Application for a Non-Material Amendment Following a Grant of Planning Permission

Langar cum Barnstone Parish Council

LCB-100-02 Proposed Plans and Elevations- Langar cum Barnstone Village Hall

LCB-100-02-Rev A Plans and Elevations- Langar cum Barnstone Village Hall

LCB/100/02/A

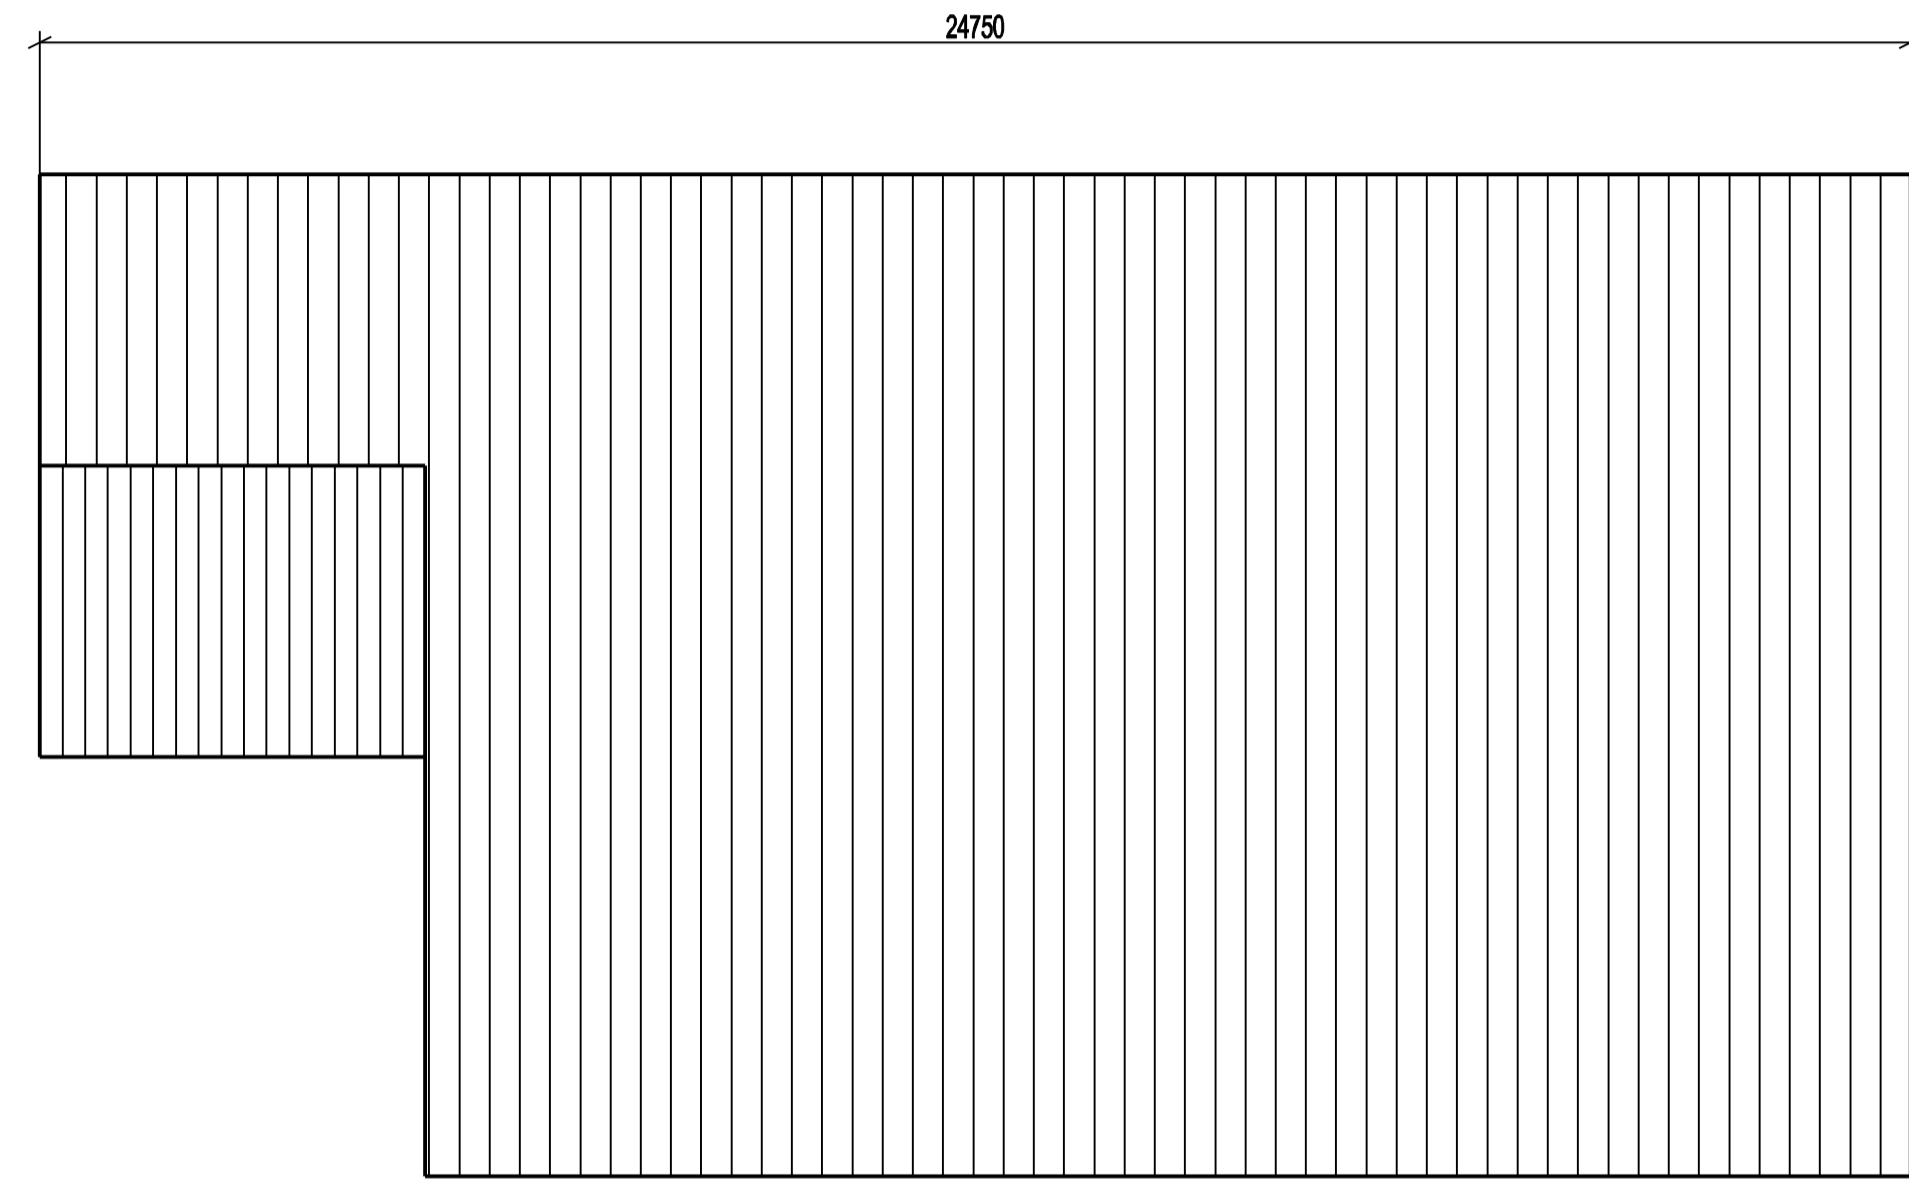
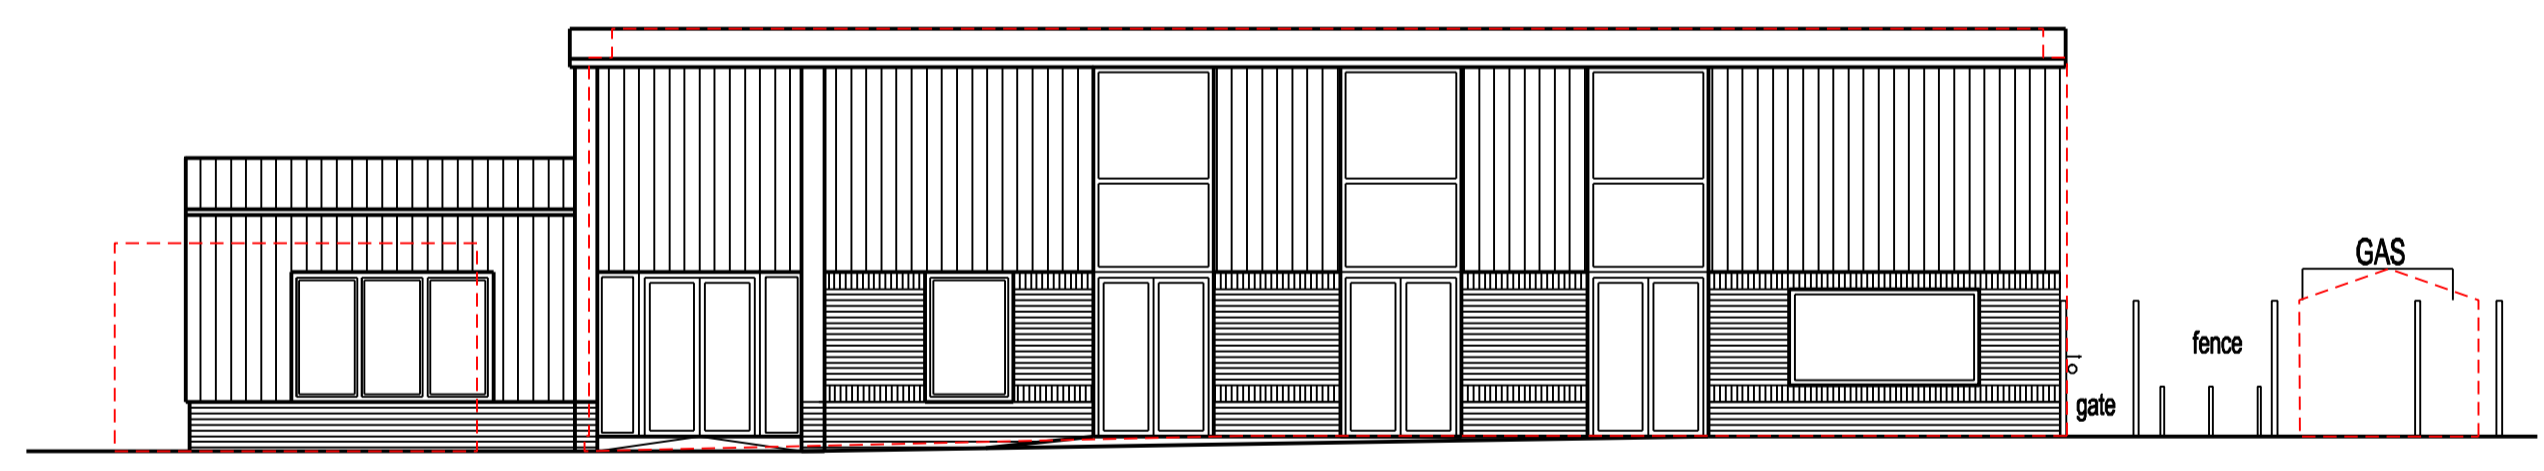
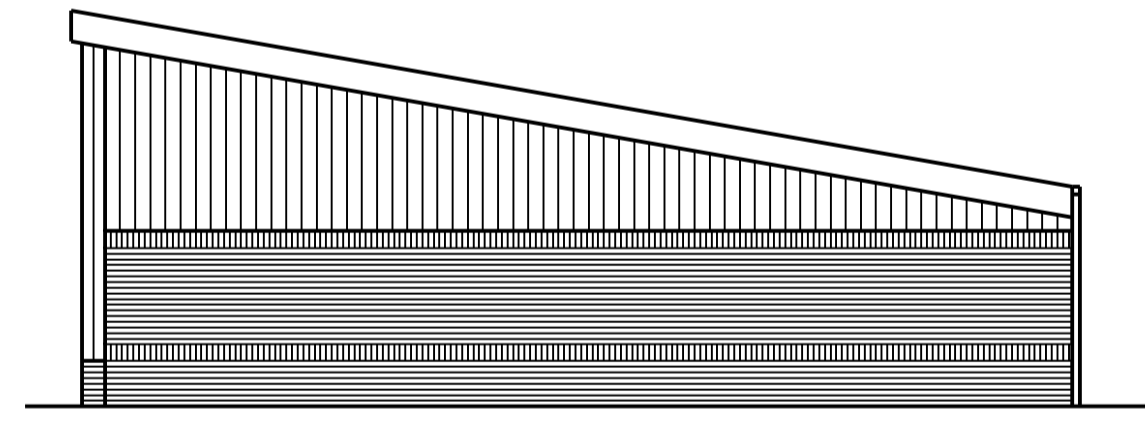
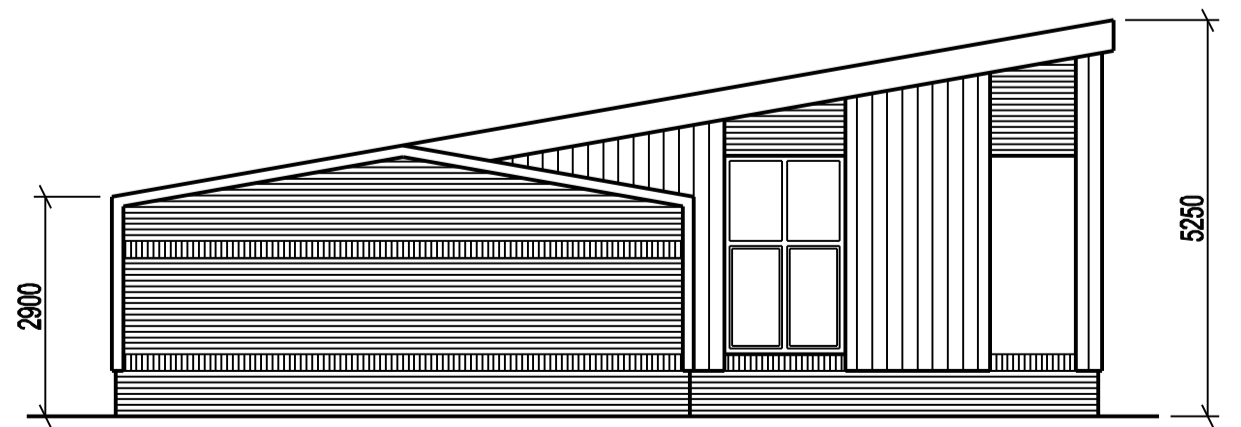
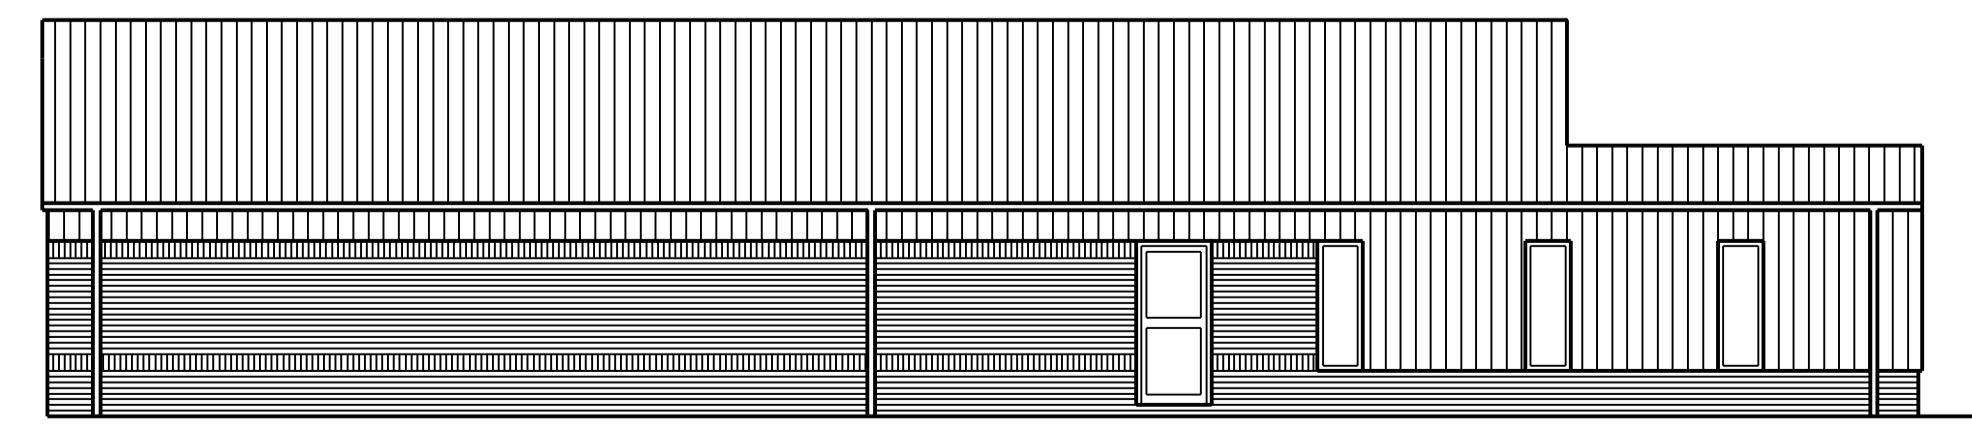
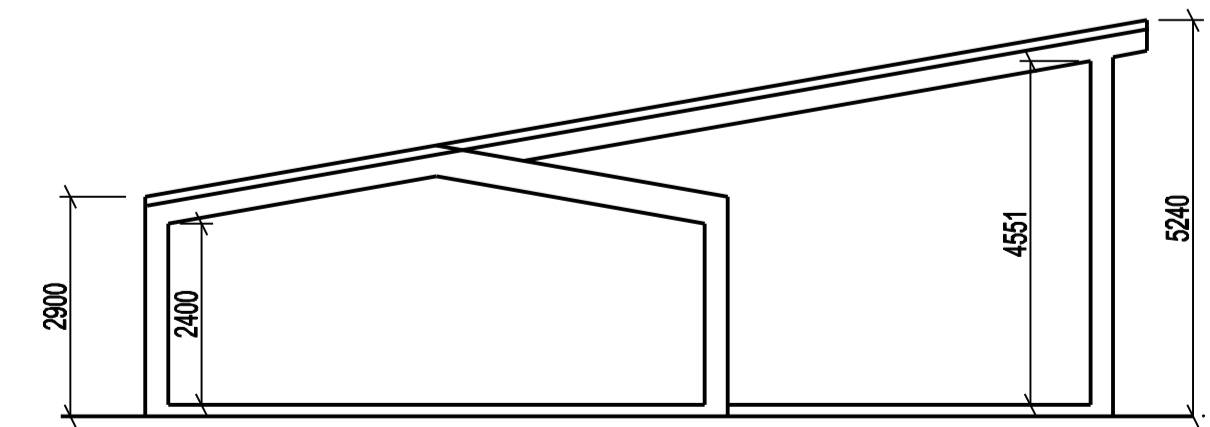
Subsequent to the attached planning permission being granted for the replacement Langar cum Barnstone Village Hall Cadent Gas have requested that an building exclusion zone of 3.0 meters be created around their adjacent gas installation. To comply with Cadent's health and safety requirements the length of the proposed hall building is to be reduced by 1250mm.
